CITY OF ALBUQUERQUE

**Re: Andaluia Villas, Tract 4 and 6 North Andaluia
Grading and Drainage Plan
Engineer's Stamp Date 6/04/2012 (E12/D015C)**

Based upon the information provided in your submittal received 8/07/2012, the above referenced submittal can not be reviewed for Building Permit Approval until the following comments have been addressed:

REVISIONS	
△	
△	
△	
DRAWN BY BHW	
REVIEWED BY JLM	
DATE 08/29/2012	
PROJECT NO. 20120222	
DRAWING NAME	
FINAL DRAINAGE PLAN

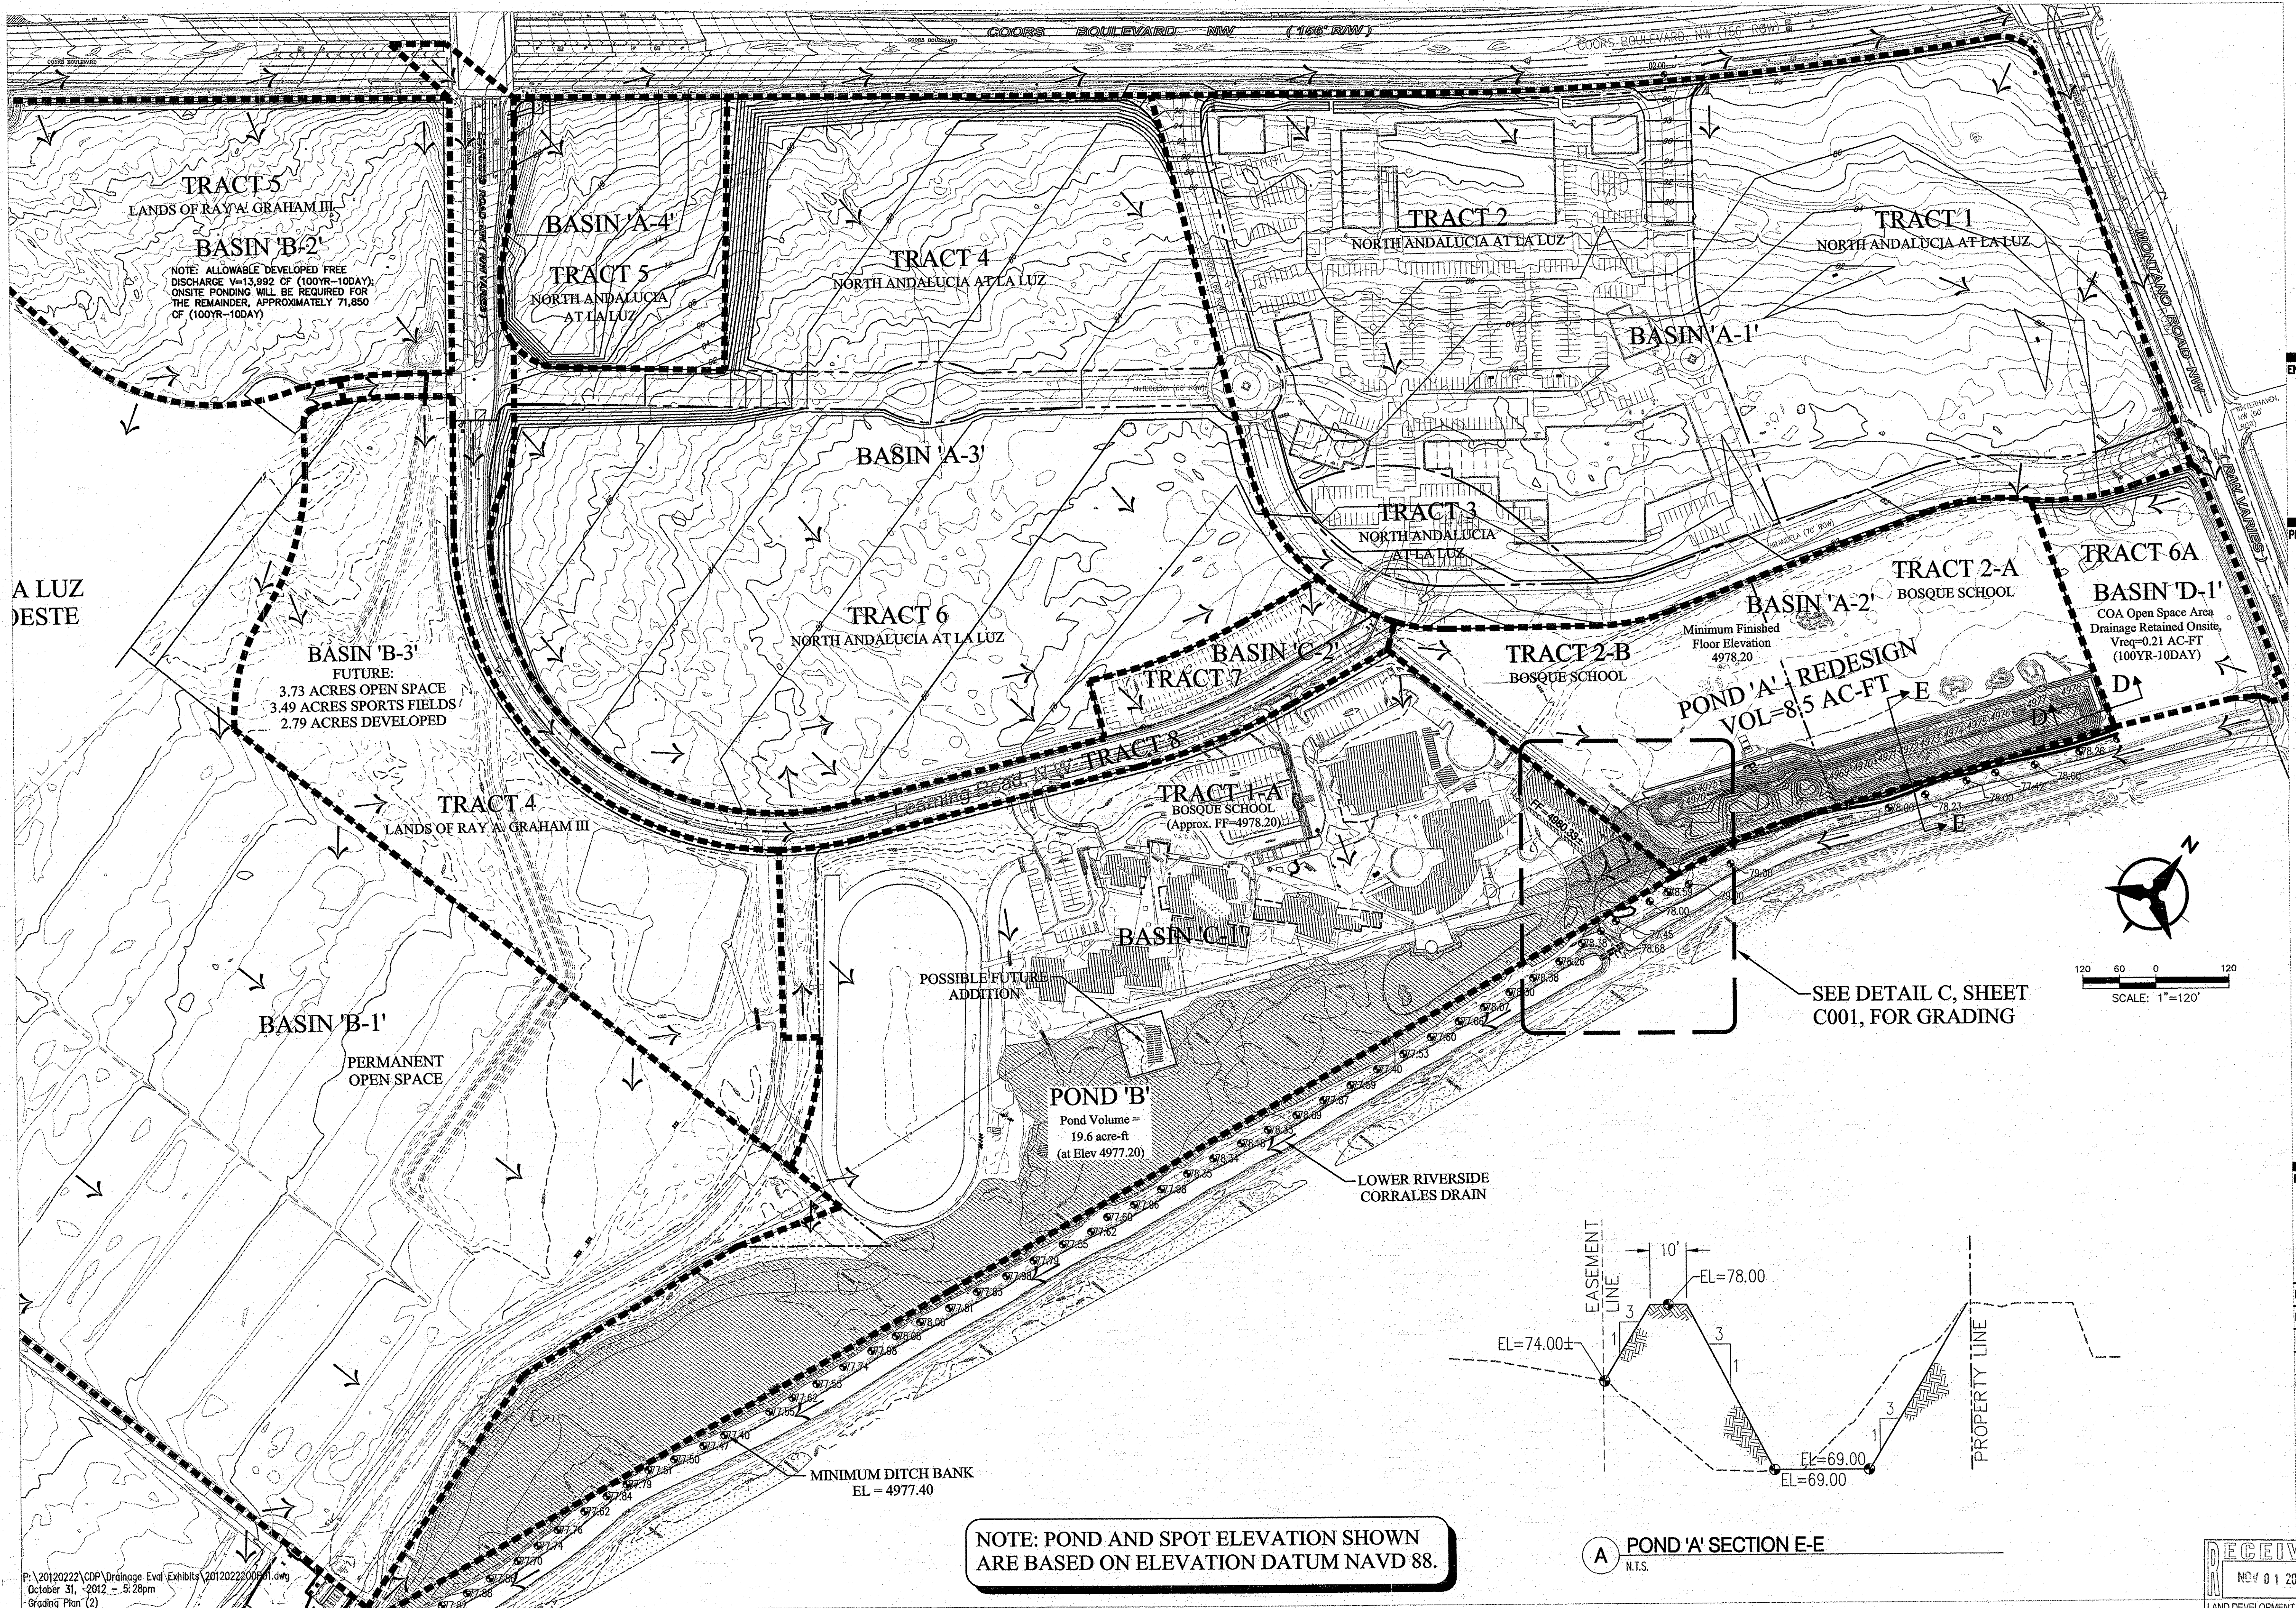
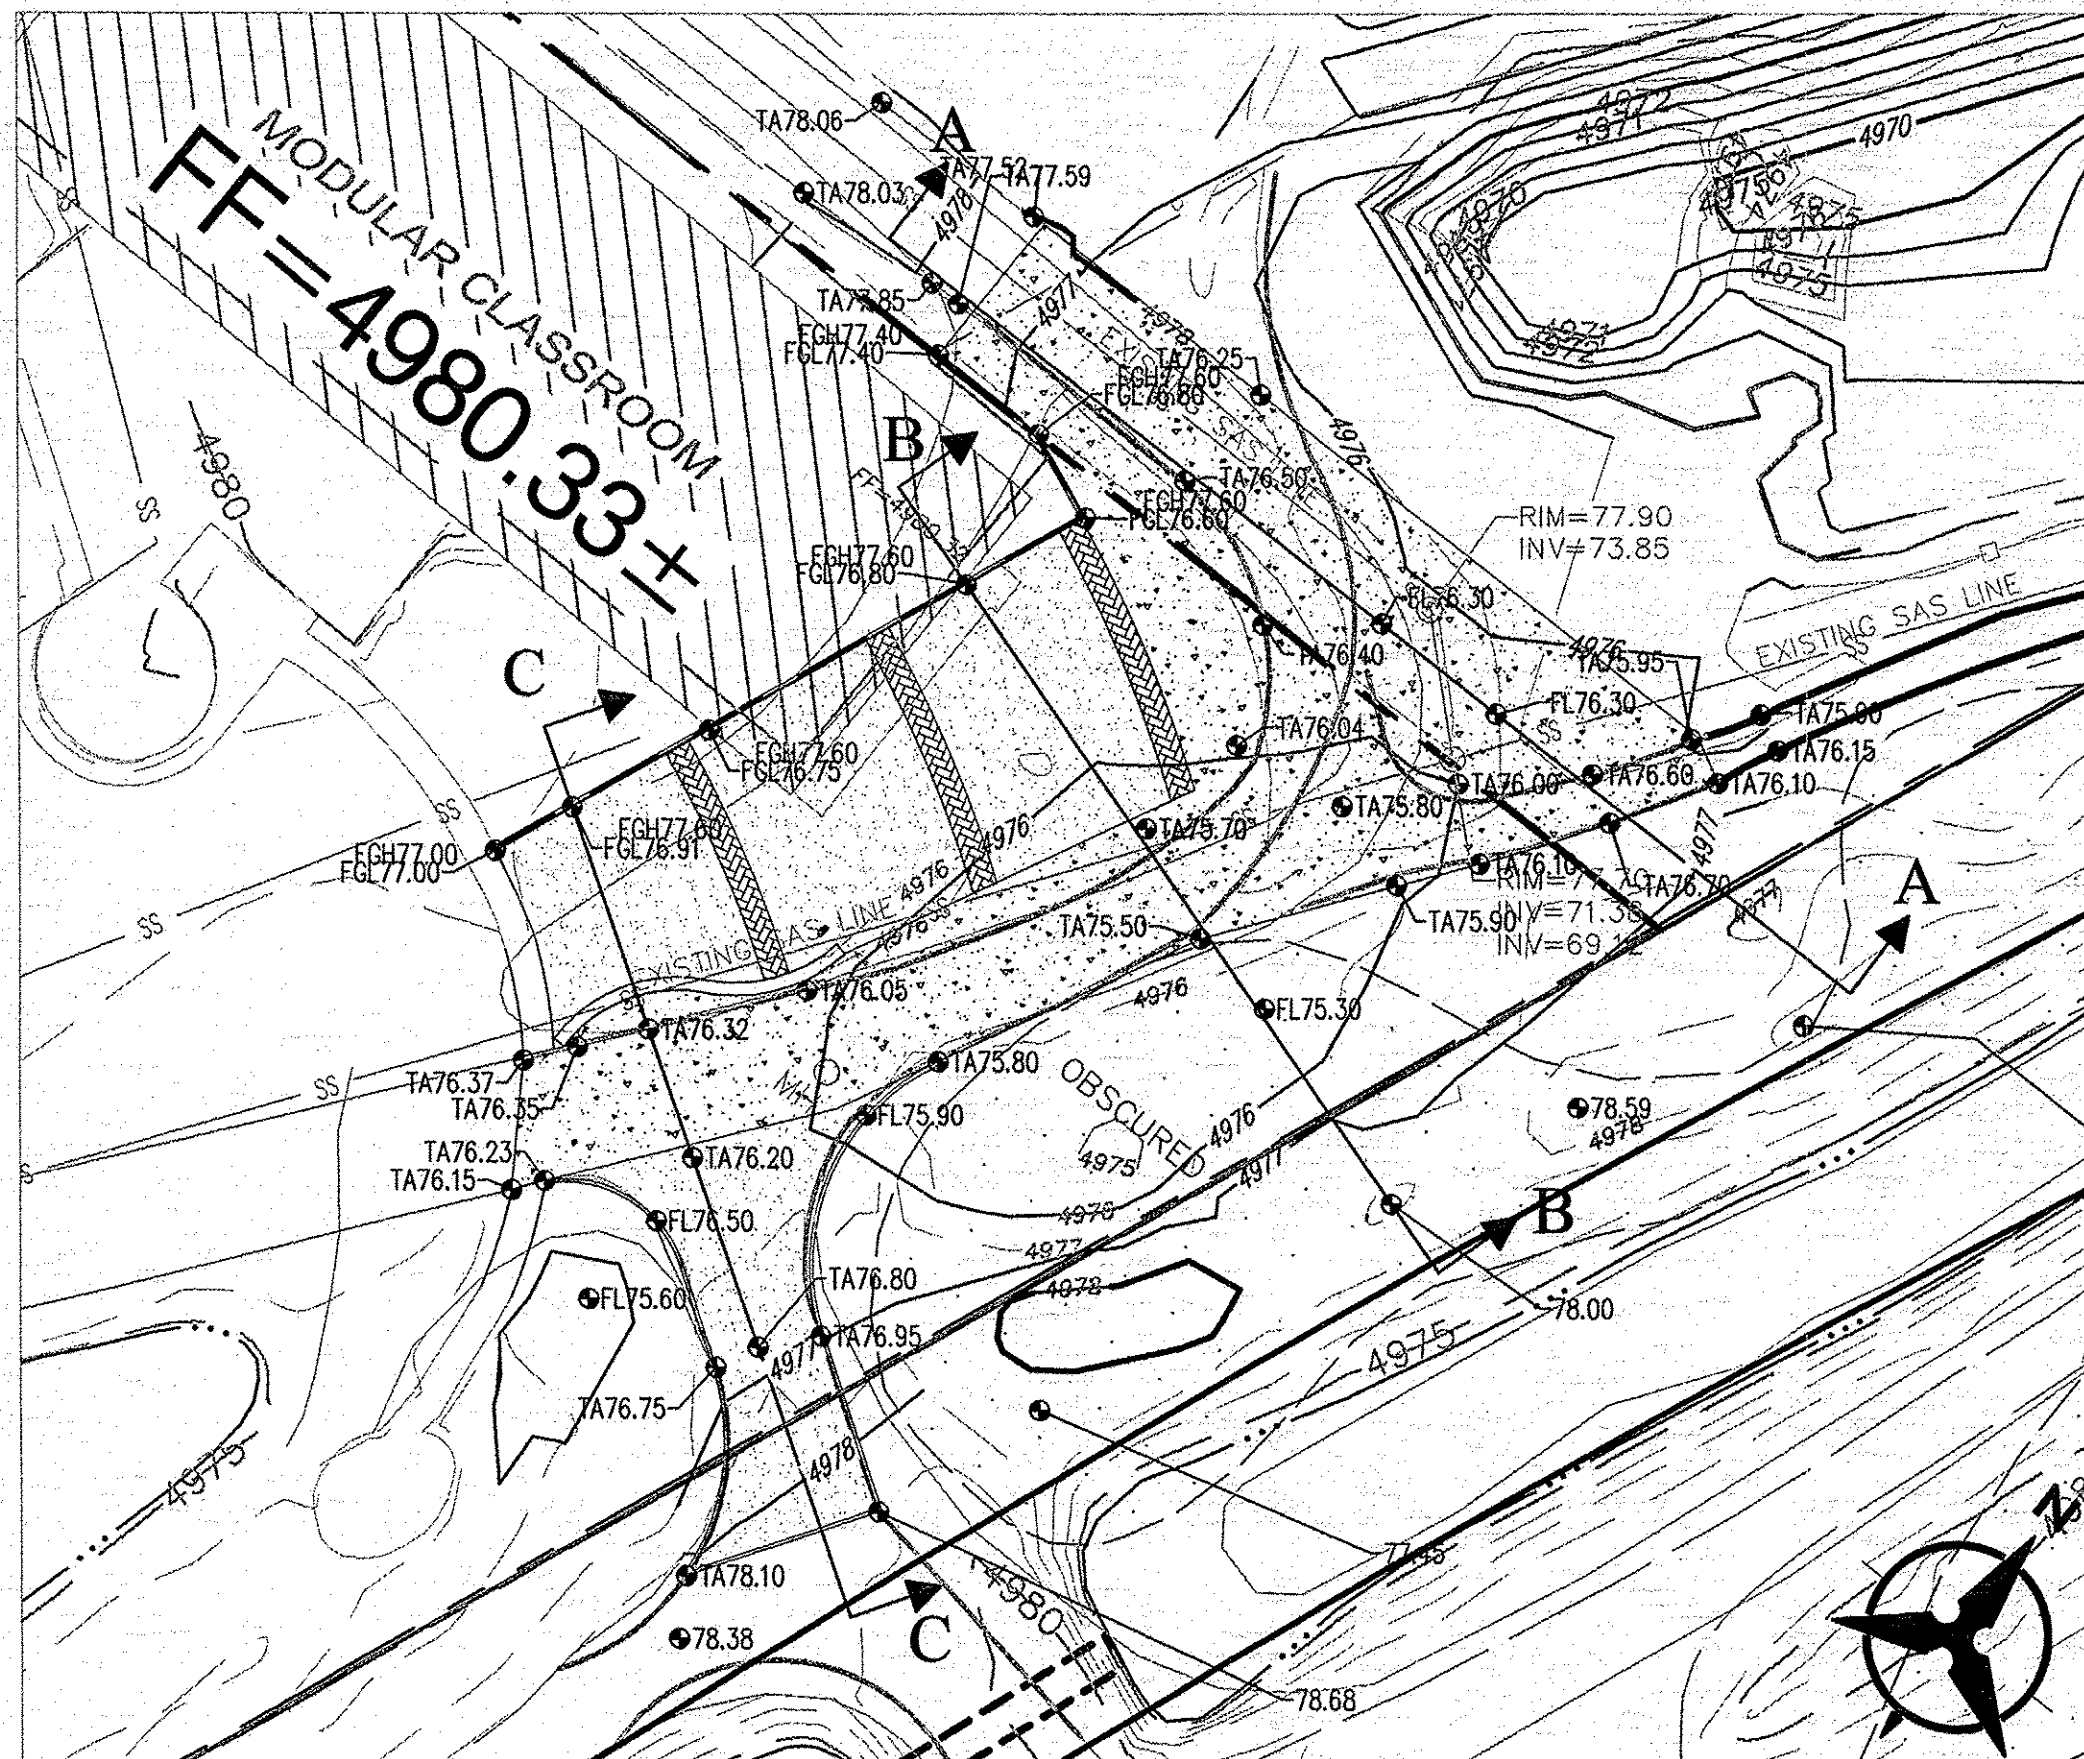
- The existing retention pond (Pond B) located on the east of the school has to be reanalyzed to assure it has adequate ponding capacity as it was intended on the Master Drainage Plan. Retention Ponds may be required for Andaluia Villas.
- The overflow from existing pond north of the school site (Pond A) to Pond B may have to be constructed. Does Pond A have to be regarded?
- Recorded drainage easement is required for Pond B.
